Bankstown City Council Submission
Re: Proposed Modifications to the 'Potts Hill Residential Design Controls' -
Section 75W Modification Potts Hill (MP08_0116 Mod 3)
Potts Hill Residential Estate

I write in reference to your letter of 02 October 2012, regarding the proposed modifications to the draft Landcom Potts Hills Residential Design Controls, for the Sydney Water land at Potts Hill (Western Residential Precinct).

Fig. 19 : Built Form Control Plan - North East Apartment site

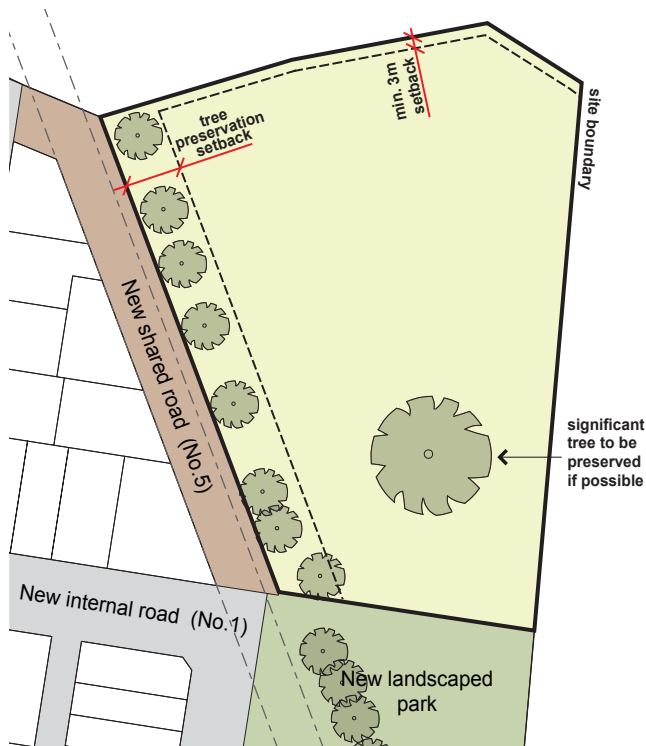
The only comment Council has regarding the document relates to the Section 3 – Apartments; where Council reiterates its original comment, that the words "*if possible*" should be deleted where-ever they appear on page 18 regarding retention of significant trees. Whilst we (Landcom and Council) have the opportunity to protect and conserve the significant trees on this apartment site (before development applications are lodged), Council would be willing to further discuss with Landcom other opportunities to review development controls for the site to ensure these trees are protected.
